**Subject: Front Entry Plan Revisions  
126-128 Danforth Street  
Portland, Maine**

Attached please find drawings revisions to the front entry to 126 & 128 Danforth Street. Design incorporates granite cheek wall redesign from 2" thick veneer panels & granite caps to solid 16" thick granite cheek wall blocks and structural foundation design.

SECTION 3

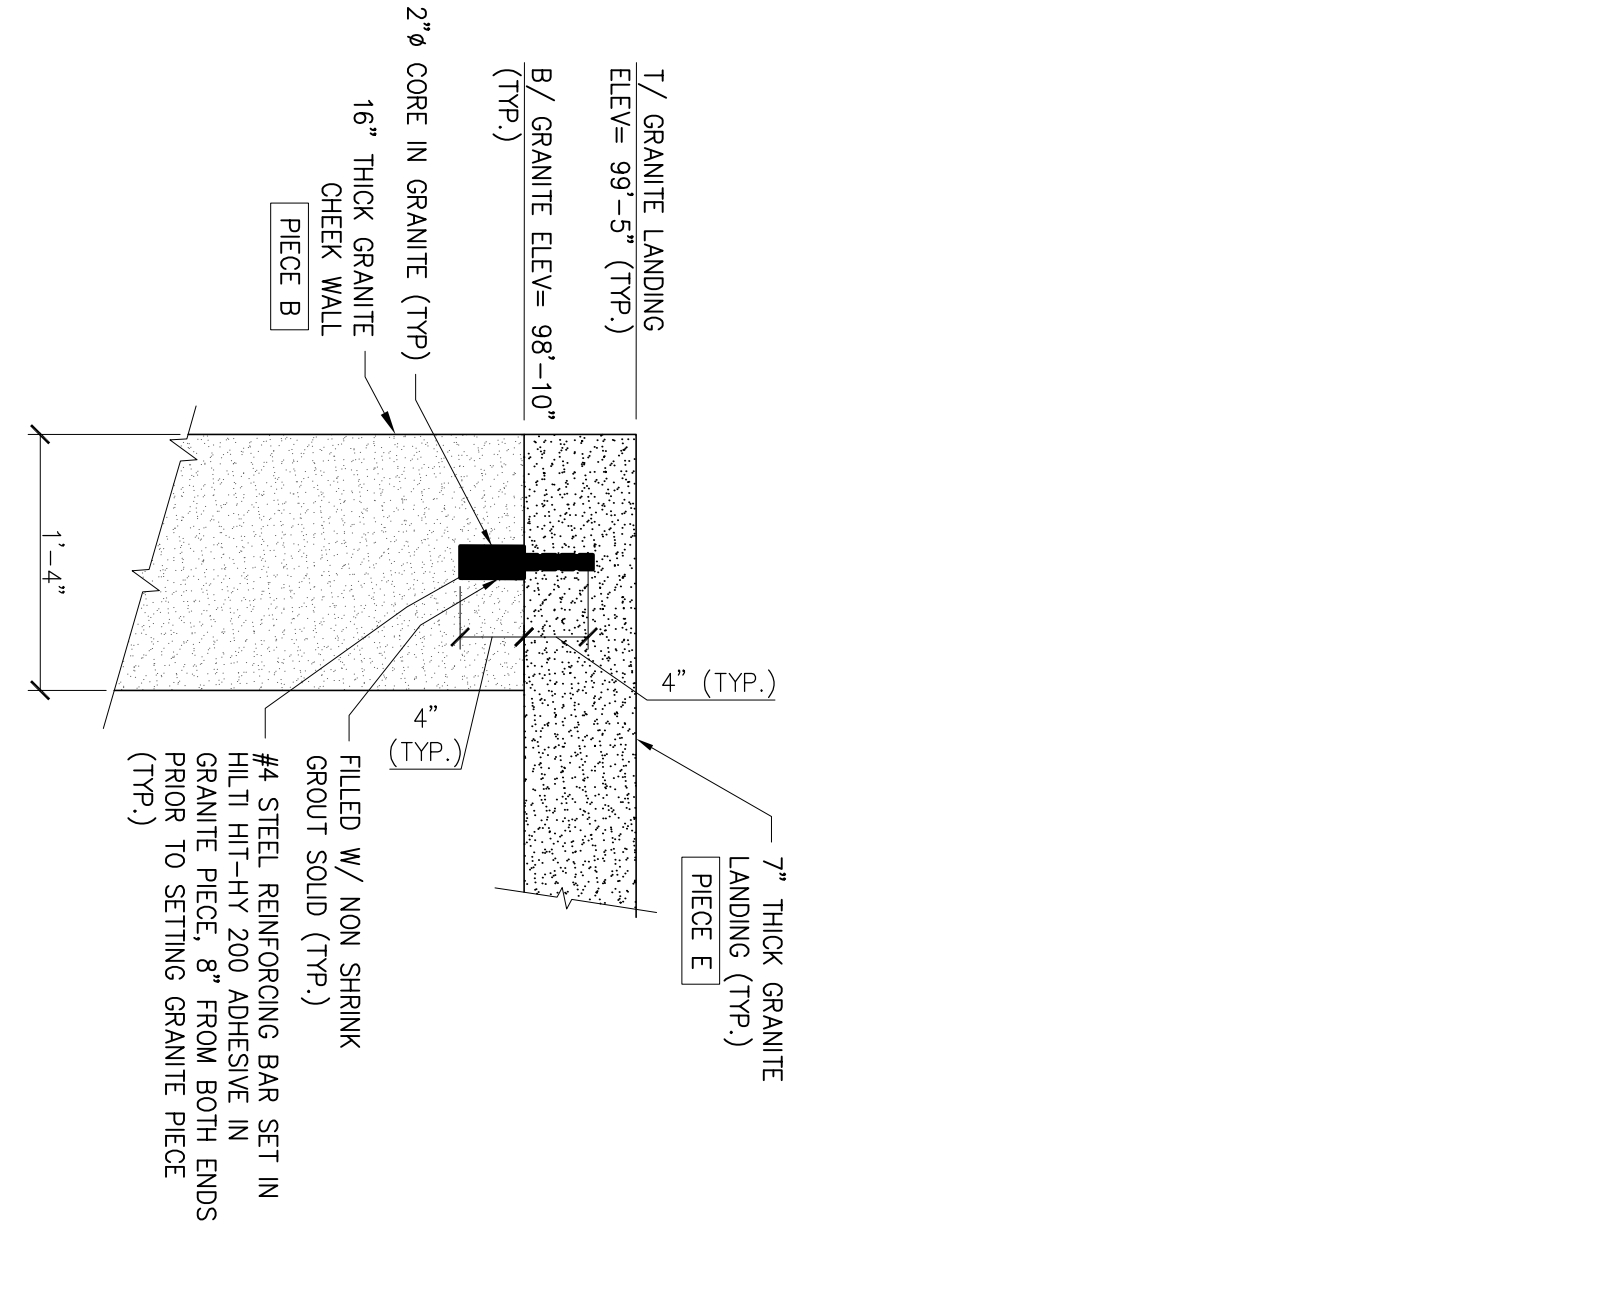
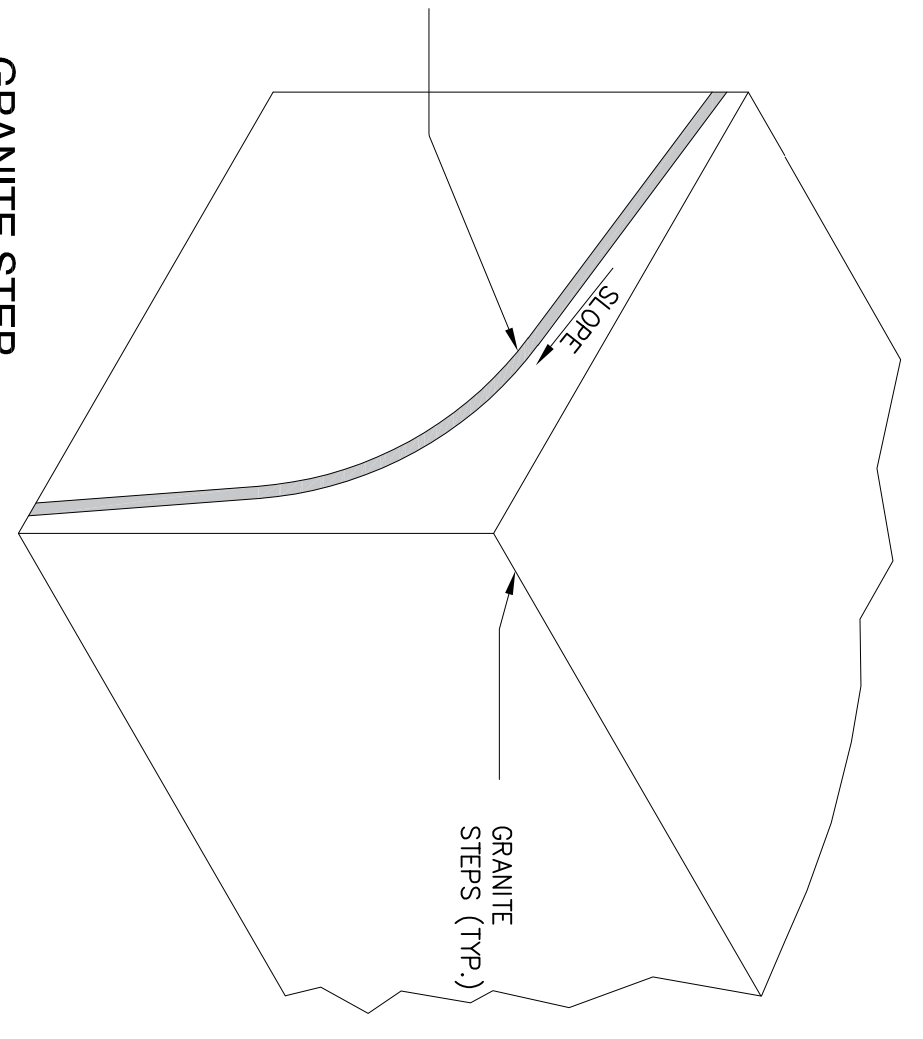
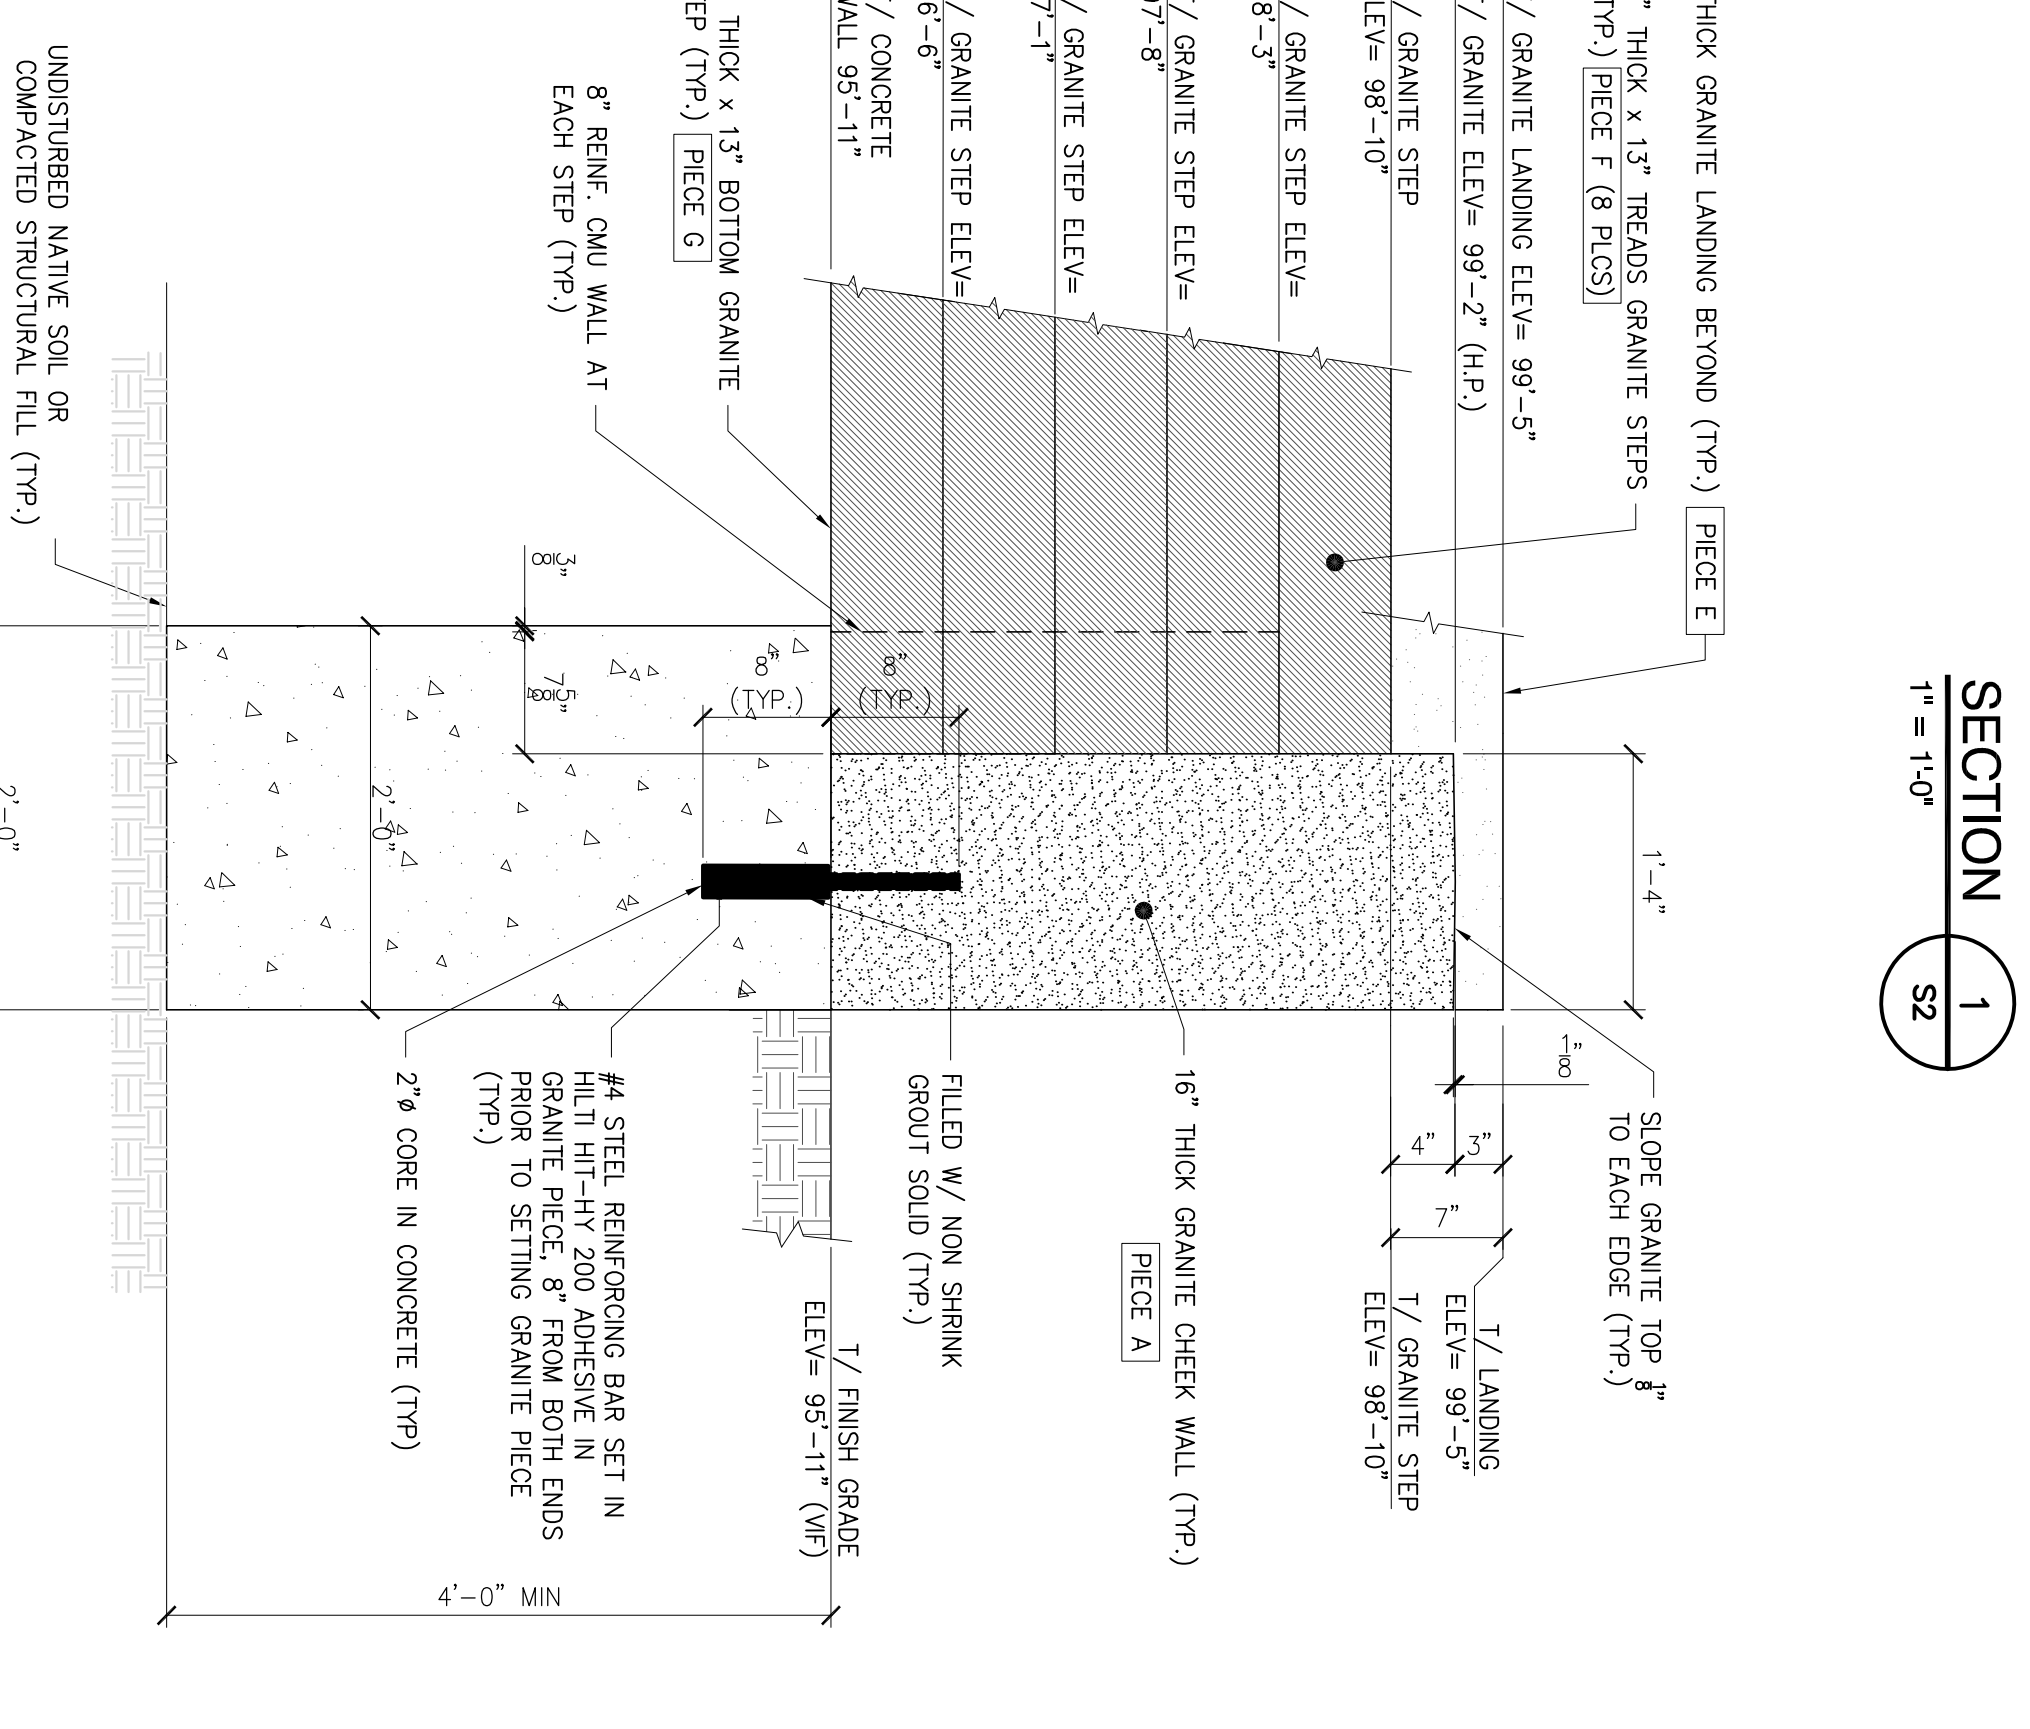
Drawings revised : **A2, A3, A5 and S1, S2, S3 and S5**
